Department of Planning, Housing and Infrastructure

Ref: SSD-73228210

Proposal: Mixed use development with affordable housing

Property: 129-153 Parramatta Road and 53-75 Queens Road, Five Dock

Figure 2: Landscape plan showing location of the substations

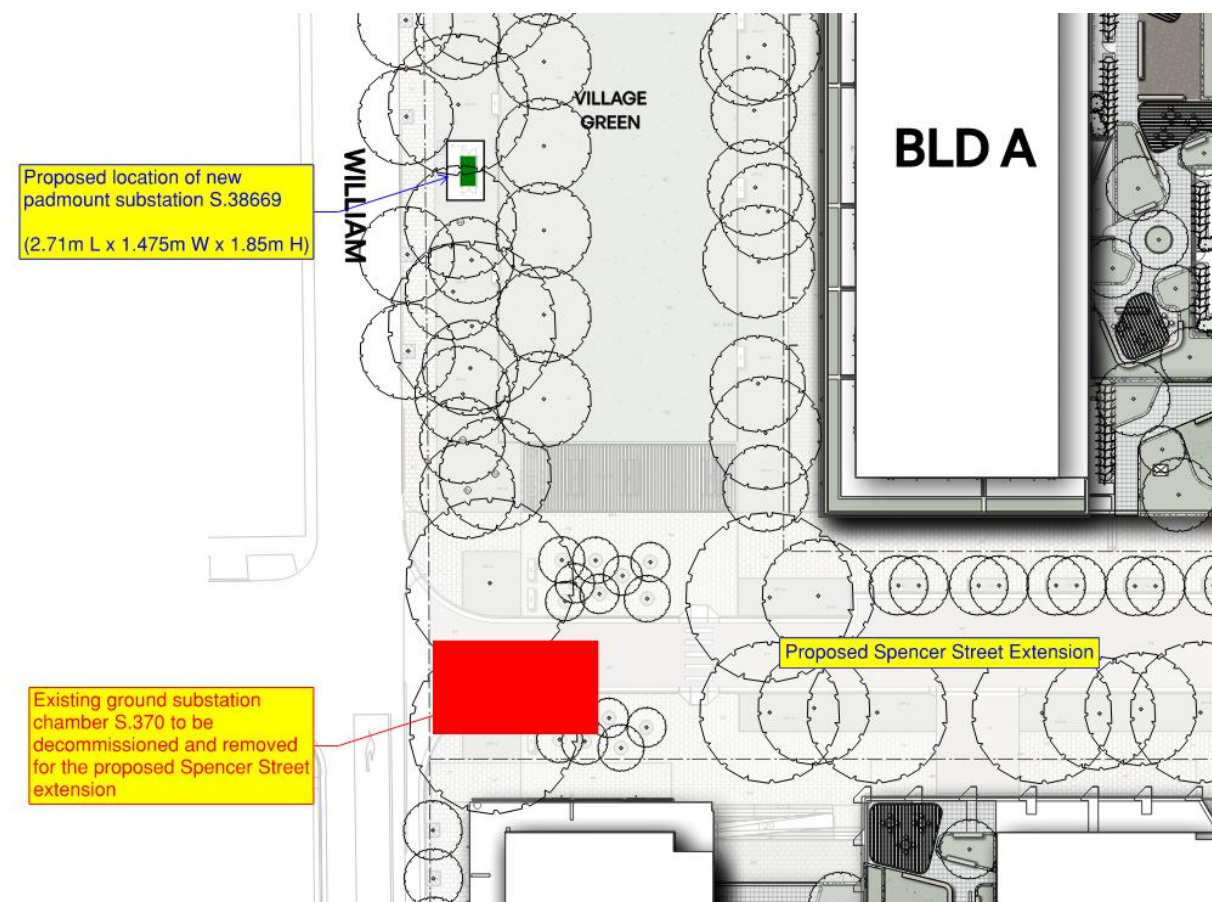
A kiosk substation is proposed within William Street Park, adjacent to Flood Hazard H4 during a 1% AEP flood event and H5/H6 during PMF. Relevant flood mitigation measures for this infrastructure have not been addressed in the flood impact and risk assessment.

It is our position that the relocated substation must be placed on the developer's private land and not within the public park or road reserve. Locating infrastructure such as a substation within public parkland or road reserves raises potential complications, including long-term maintenance, access issues, and future land use conflicts. The substation must be located within the developer's land boundaries to ensure proper management and mitigate potential issues related to land tenure or accessibility.
